CITY OF ALBUQUERQUE

**RE: Geneivas Arroyo
CLOMR Request
Engineer's Stamp Date: 1-9-2026
Hydrology File: L15D006
Case # HYDR-2026-00007**

Based upon the information provided in your submittal received 1/9/2026, the CLOMR Request needs modifications before it can be submitted to FEMA with the City's concurrence. The following comments need to be addressed for the above referenced project:

**EXHIBIT 2
ANNOTATED FIRM
Panel 2 of 3**

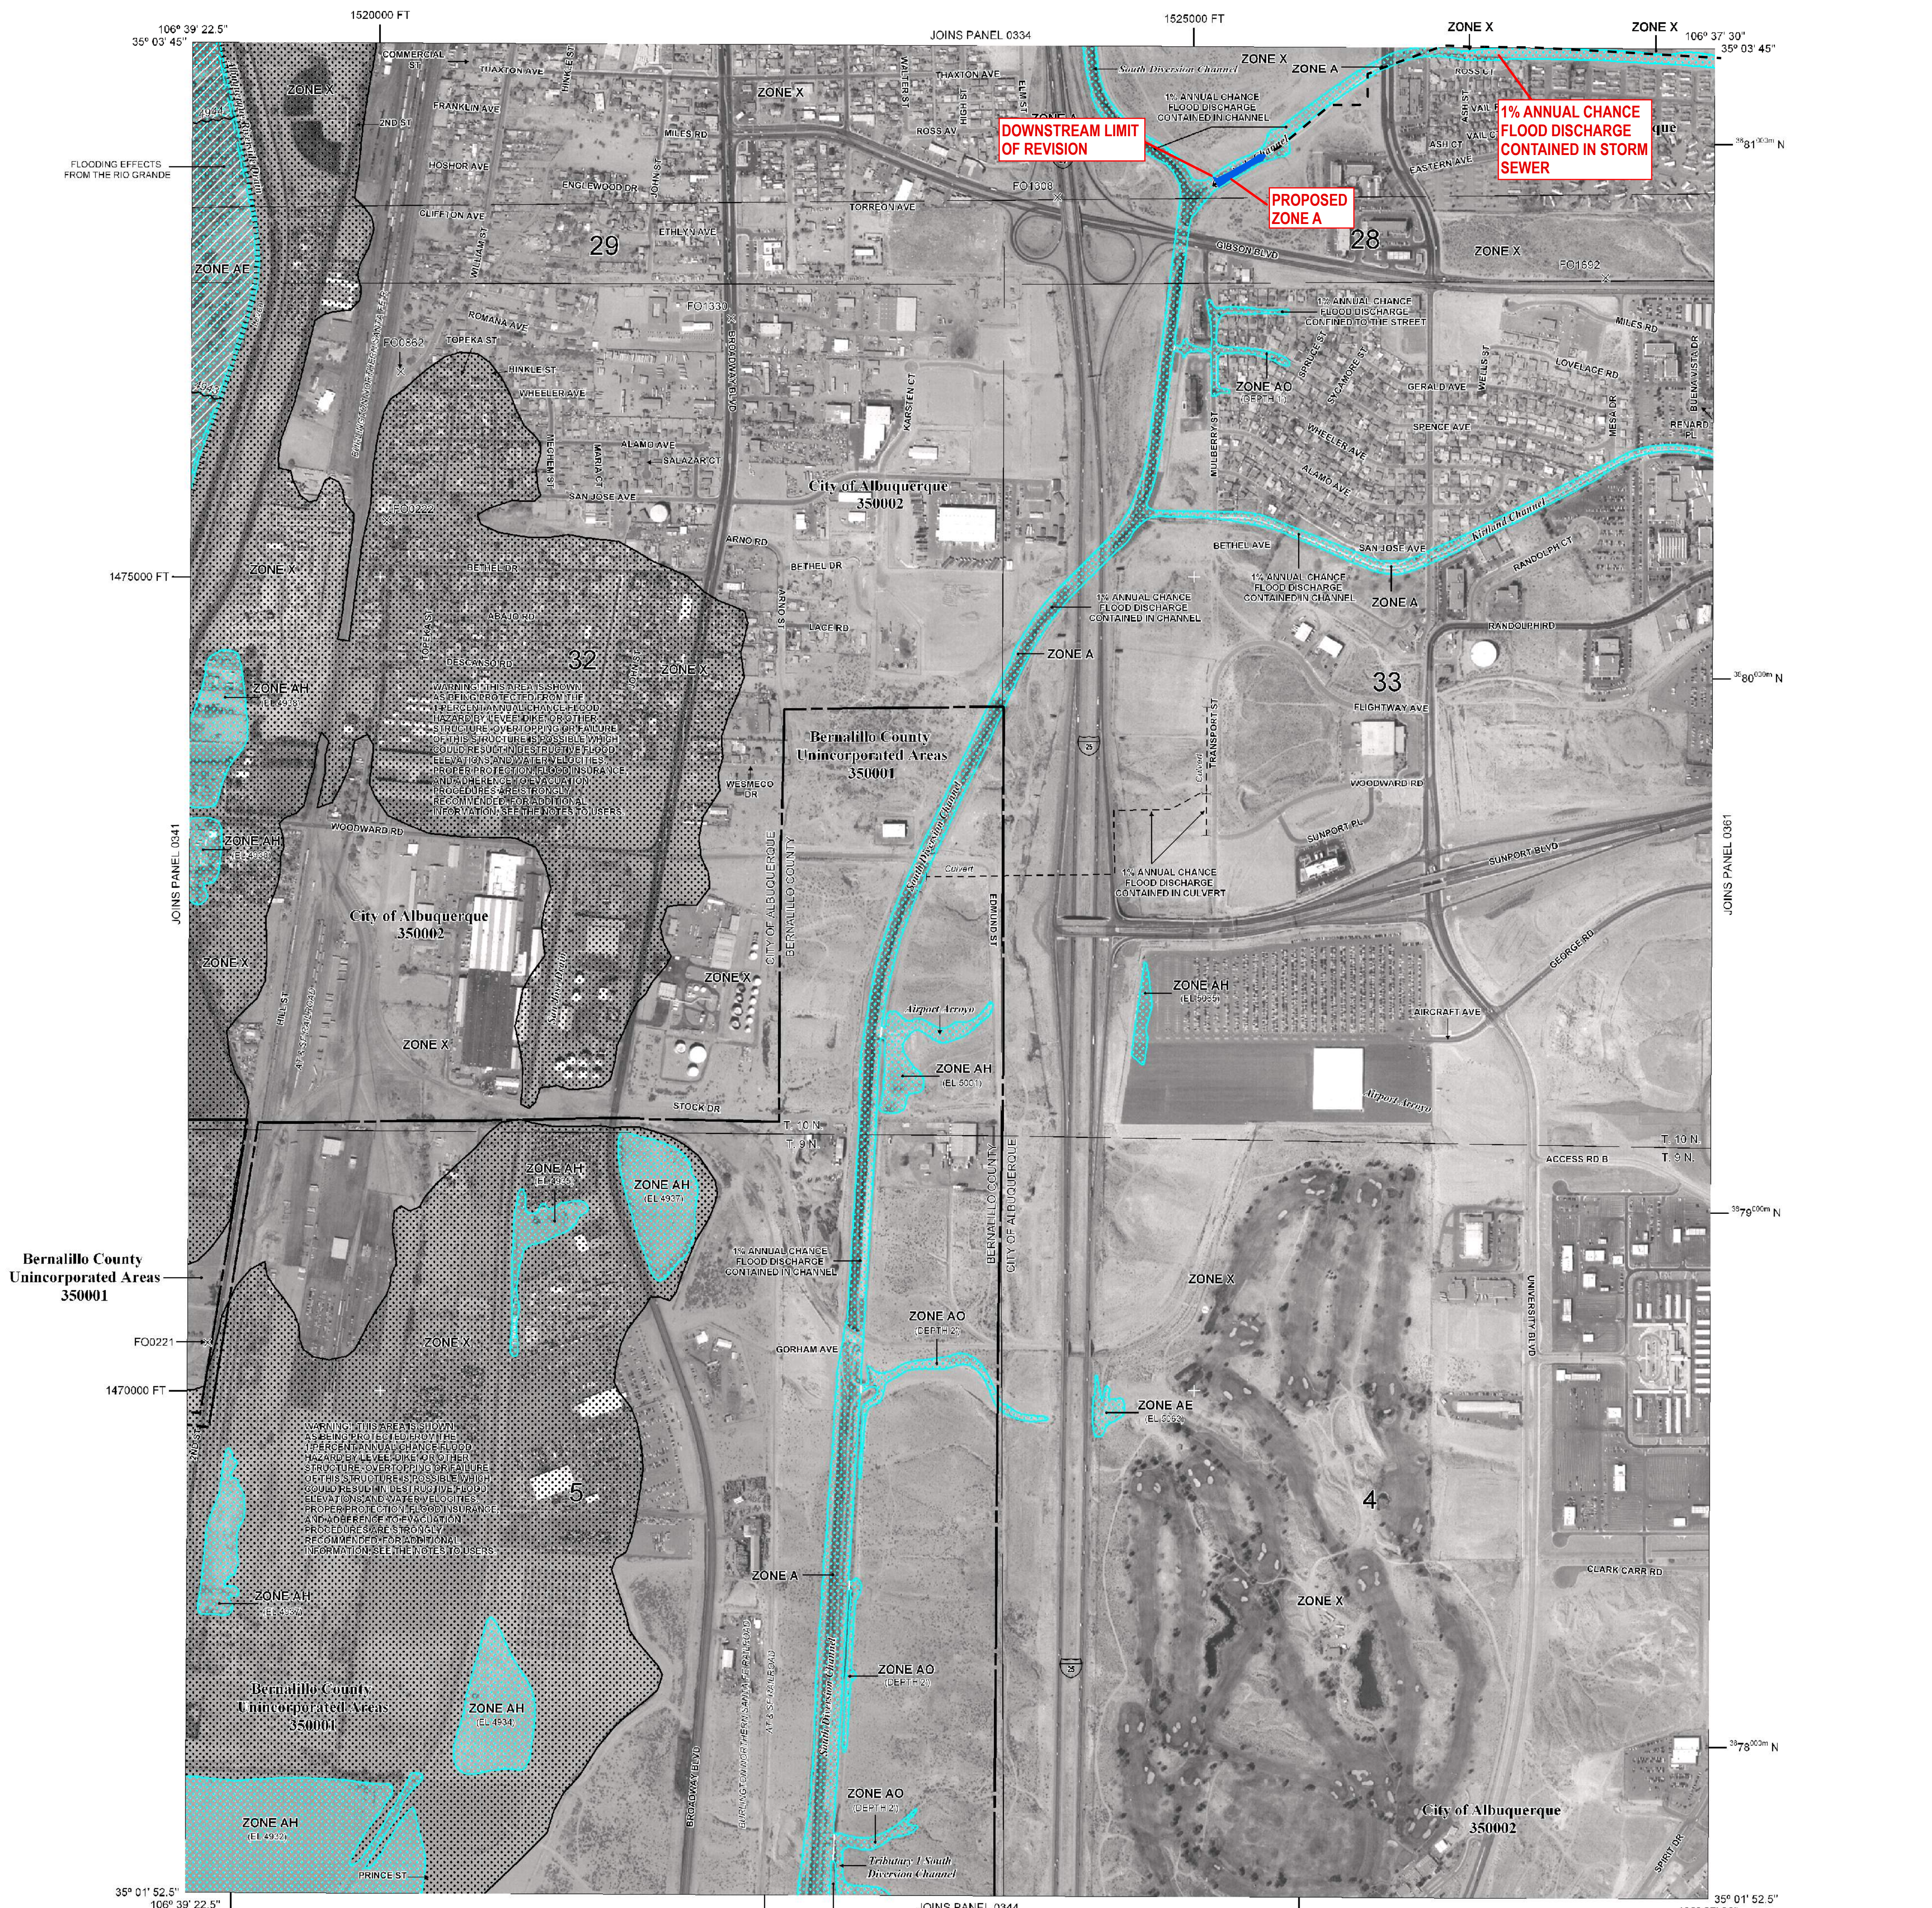
- Pg 14 of 65 - #1 – Split City and County on two lines. Make sure that the Panel numbers are all clearly shown.
